<b>Application Ref:</b>	3/2025/0177			 Ribble Valley Borough Council <small>www.ribblevalley.gov.uk</small>
<b>Date Inspected:</b>	10/1/24	<b>Site Notice:</b>	18/4/25	
<b>Officer:</b>	BT			
<b>DELEGATED ITEM FILE REPORT:</b>				<b>APPROVAL</b>

<b>Development Description:</b>	Listed Building Consent for the proposed conversion of Green Barn to create 1no dwelling with associated parking and amenity space. Conversion of Outbuilding 02 to form 2no storage / workshop spaces to serve the proposed barn conversion and Eaves House Farm. Partial Conversion of Outbuilding 01 to form new home office in relation to the existing listed farmhouse.
<b>Site Address/Location:</b>	Eaves House Farm, Waddington Road, West Bradford, BB7 3JF.

| Proposed ground floor plan & elevations of Green Barn. | | | |

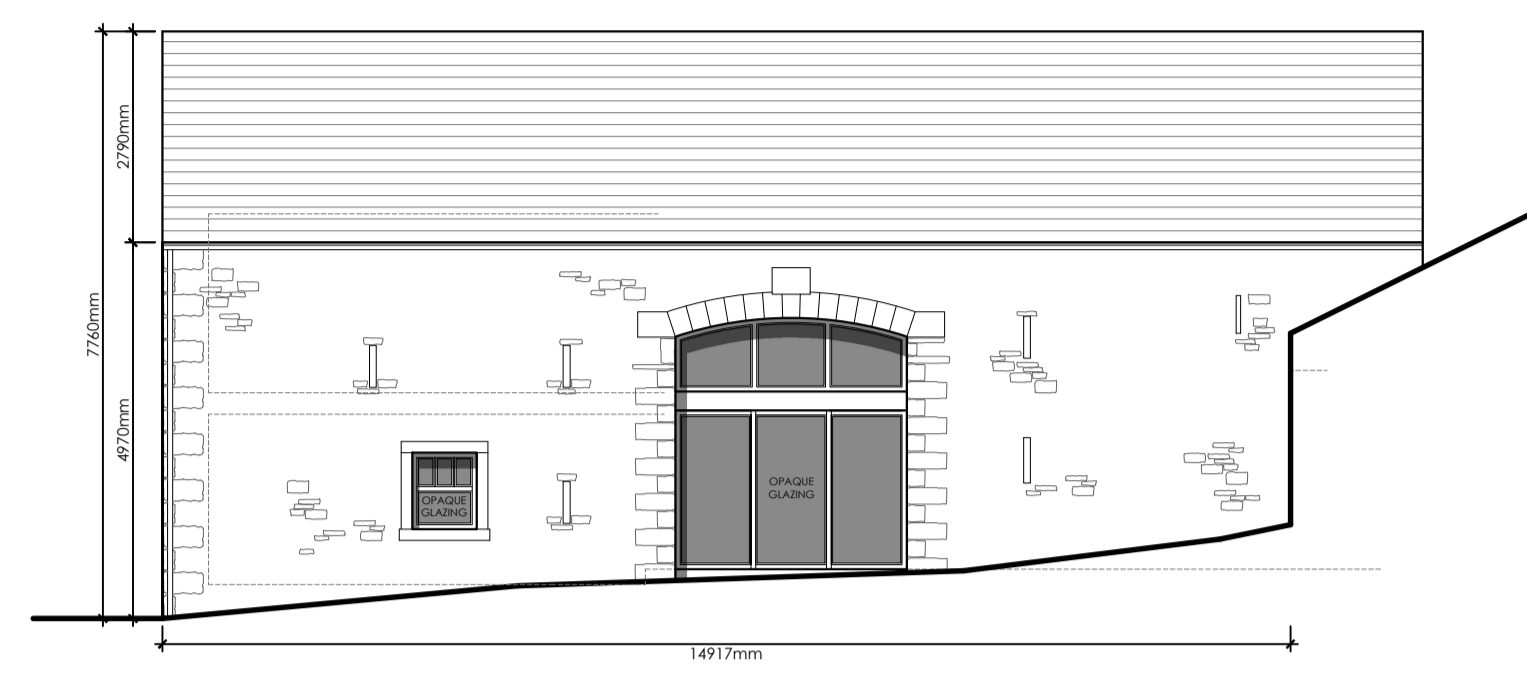
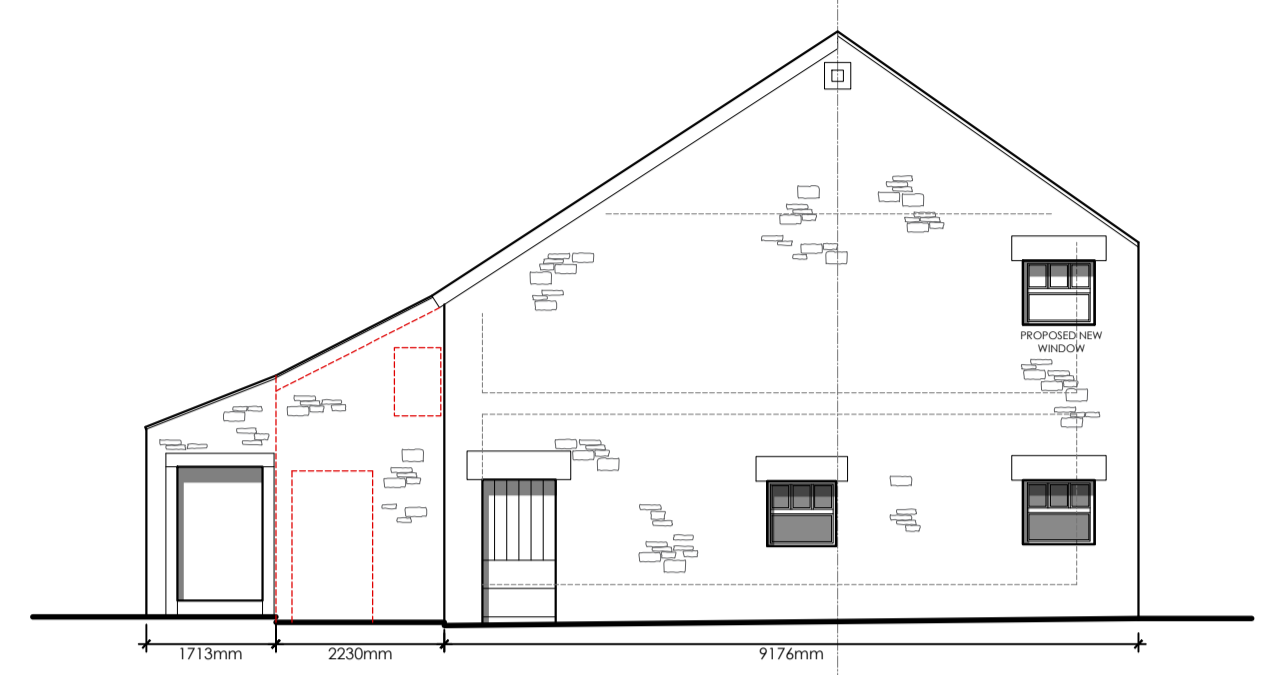
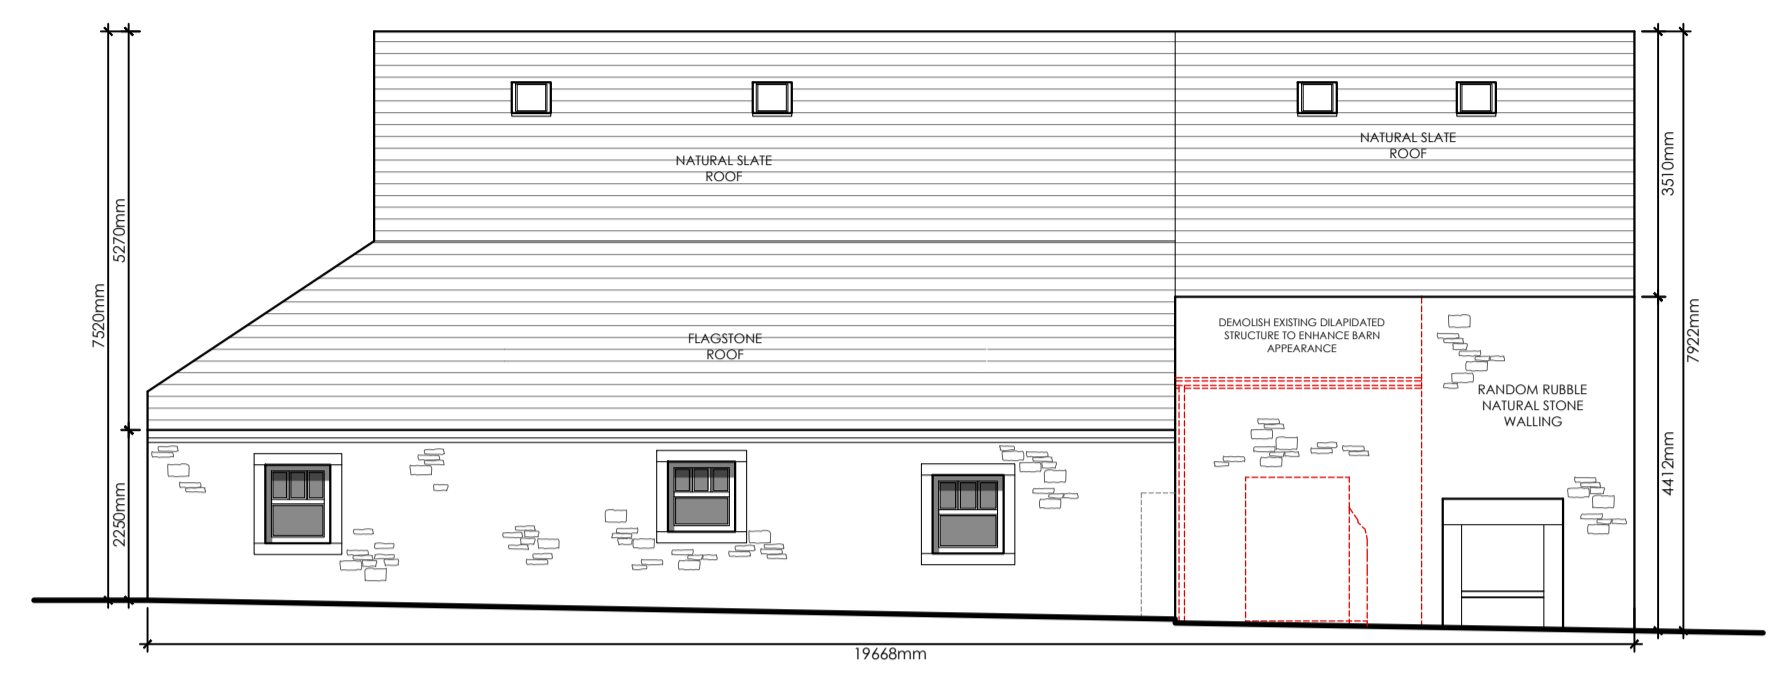
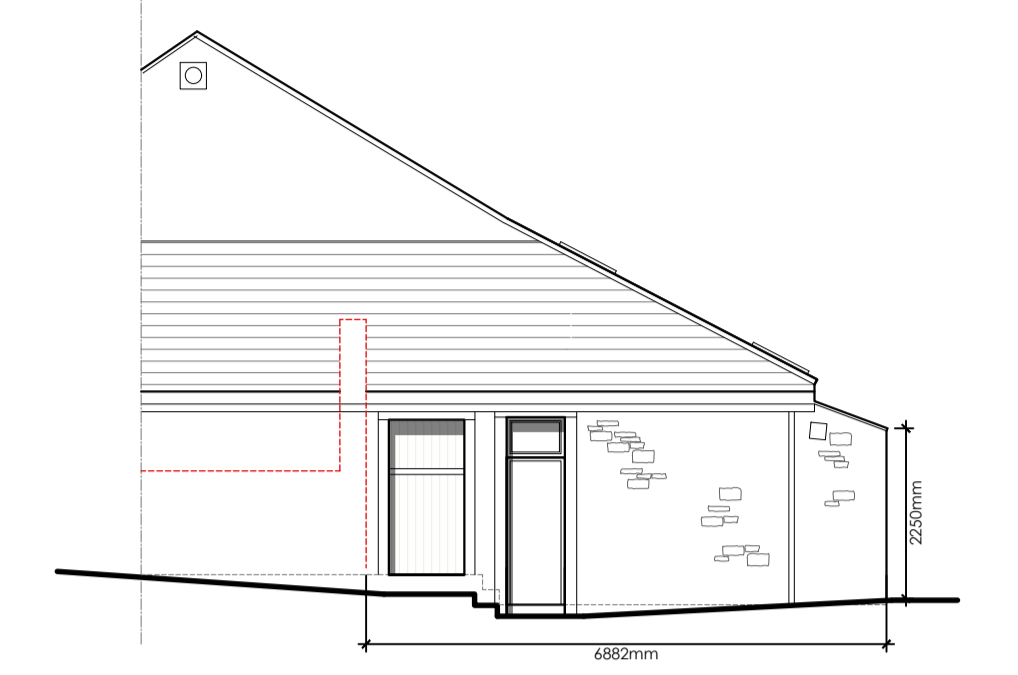
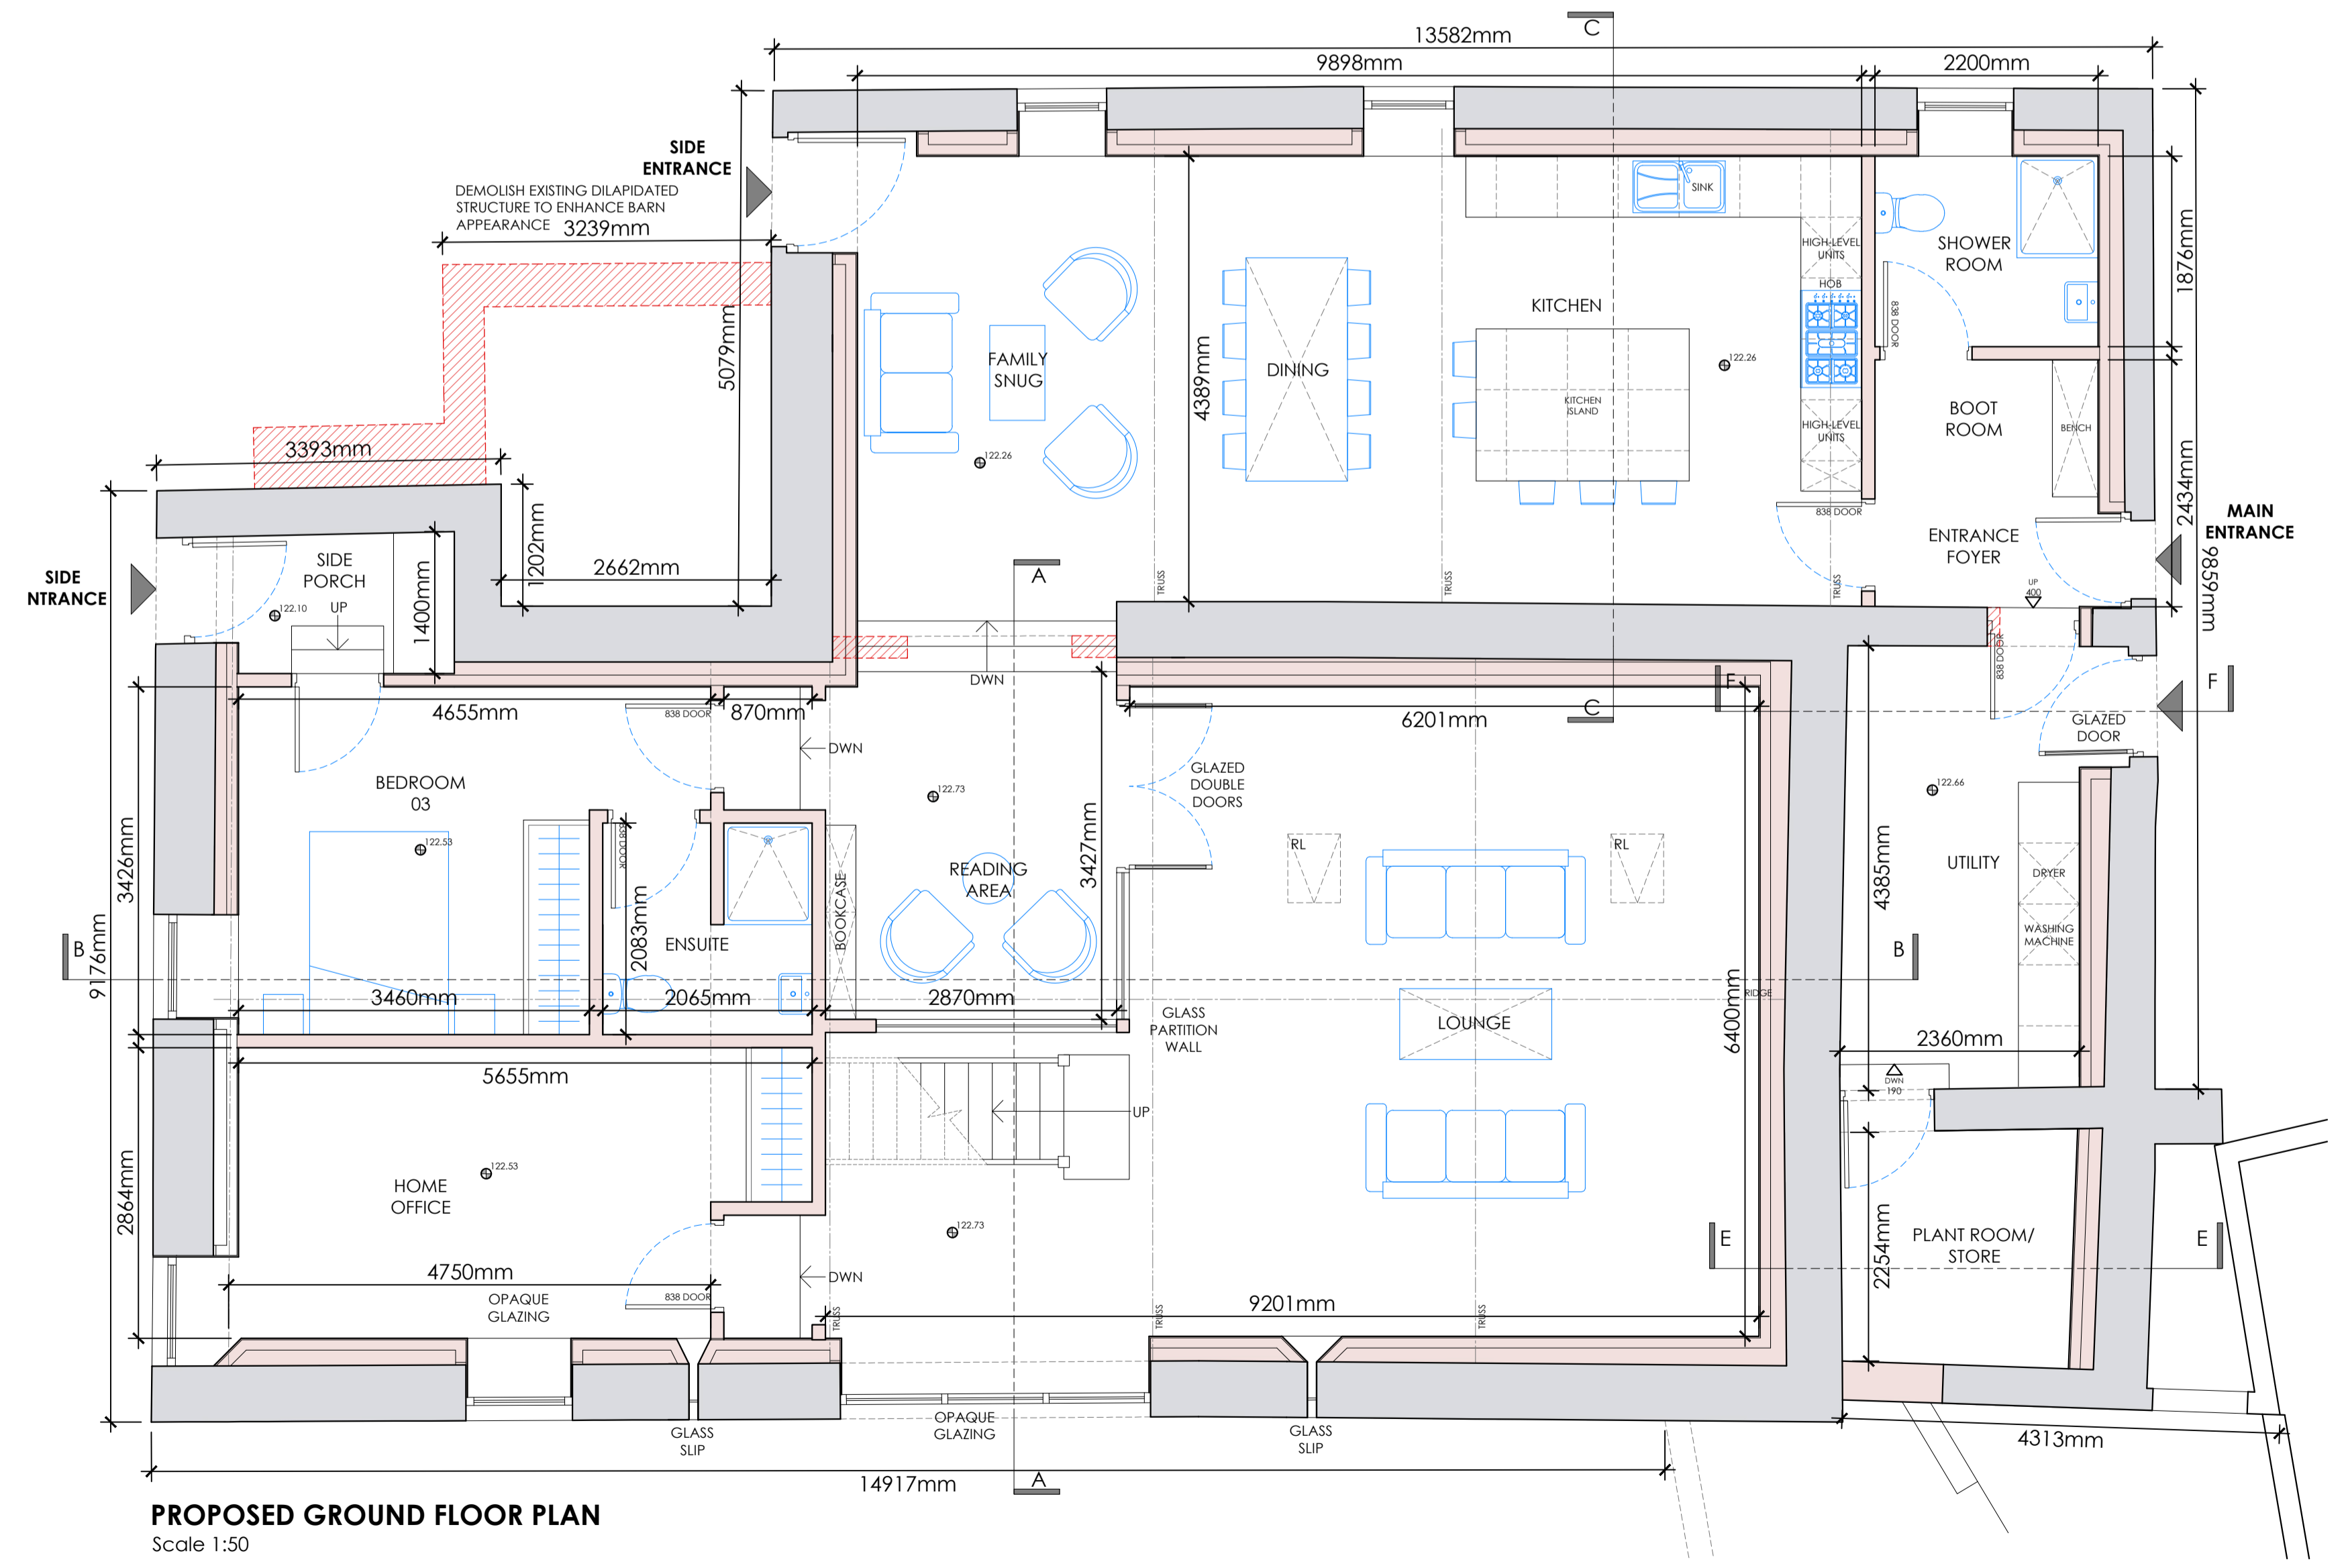
The block / render lean-to adjoining the barn's rear North-western elevation is a later modern addition to the historic barn with its external elevations detracting from the traditional stone based vernacular of the barn. Similarly, the roof profile of the block / render lean-to and Southern portion of the barn's rear North-western roof slope are currently comprised of corrugated metal sheeting which is equally at odds with the natural slate roof profile of the barn building. Consequently, the removal of the later lean-to feature and replacement of the barn's corrugated metal sheeting with natural slates would deliver a discernible enhancement to the character and appearance of the historic barn building therefore these works are considered to be acceptable. In addition, the remainder of the barn's roof would be stripped and re-slatted through the use of the building's existing natural roof slates which would help to preserve the barn's existing timber roof structure through the creation of a watertight roof that would prevent further deterioration and collapse. Accordingly, the re-slating and replacement of the building's existing roofing materials is considered to be acceptable, subject to the provision of further details in the form of samples or detailed specifications of any replacement roof slates, and on the basis of any replacement roof slates matching the existing roof slates in appearance, size and quality.

The existing rainwater goods in place on the barn building comprise a mixture of UPVC and metal which appear to be somewhat worn in terms of their external appearance. As such, the existing rainwater goods offer little value to the character and appearance of the barn therefore their removal and replacement with new rainwater goods could potentially deliver an enhancement to the character and appearance of the historic barn building. Notwithstanding this, the application's heritage statement indicates that states that the replacement rainwater goods would comprise an aluminium based design which is not considered to be a wholly appropriate material for use on a traditional barn building (it is considered that cast iron rainwater goods would be more befitting, and these would also match the materiality of the rainwater goods approved for Eaves House Farm under application 3/2023/0907).

In this instance, the proposed scheme of residential conversion would be predominantly centred around the use of the barn's historic openings, with all windows and door frames finished in a timber detailing which would be wholly appropriate for the agricultural character of the building and rural setting of the site. Furthermore, it is stated that all new window frames and doors would be recessed back into the barn's openings so as to reduce their visual impact, with the new glazed timber frame to be installed within the main cart opening also being set back to expose the full depth of the original stone wall. As such, the cumulative treatment proposed to the barn's openings would be respectful to the heritage asset and is therefore considered to be acceptable, subject to the provision of further details with respect to glazing detail, moulding finish and method of opening, fixing and finish. A new first floor window opening is proposed for the South-western elevation of the barn. This would be a modestly sized opening serving a habitable room and its proportions would be in keeping with the proportionality of the ground floor window openings sited directly below. As such, the proposed window opening would be respectful to the character and appearance of the barn and the resultant loss of historic building fabric from the proposed window opening would not be significant. Accordingly, the proposed introduction of one additional window opening is considered to be justifiable and it is not considered that this would be unduly harmful to the significance of the heritage asset.

Accordingly, the replacement of the building's existing rainwater goods is considered to be acceptable, subject to the provision of further details in the form of samples or detailed specifications of the new rainwater goods to be installed, method(s) of fixing and further details of the proposed paint finish.
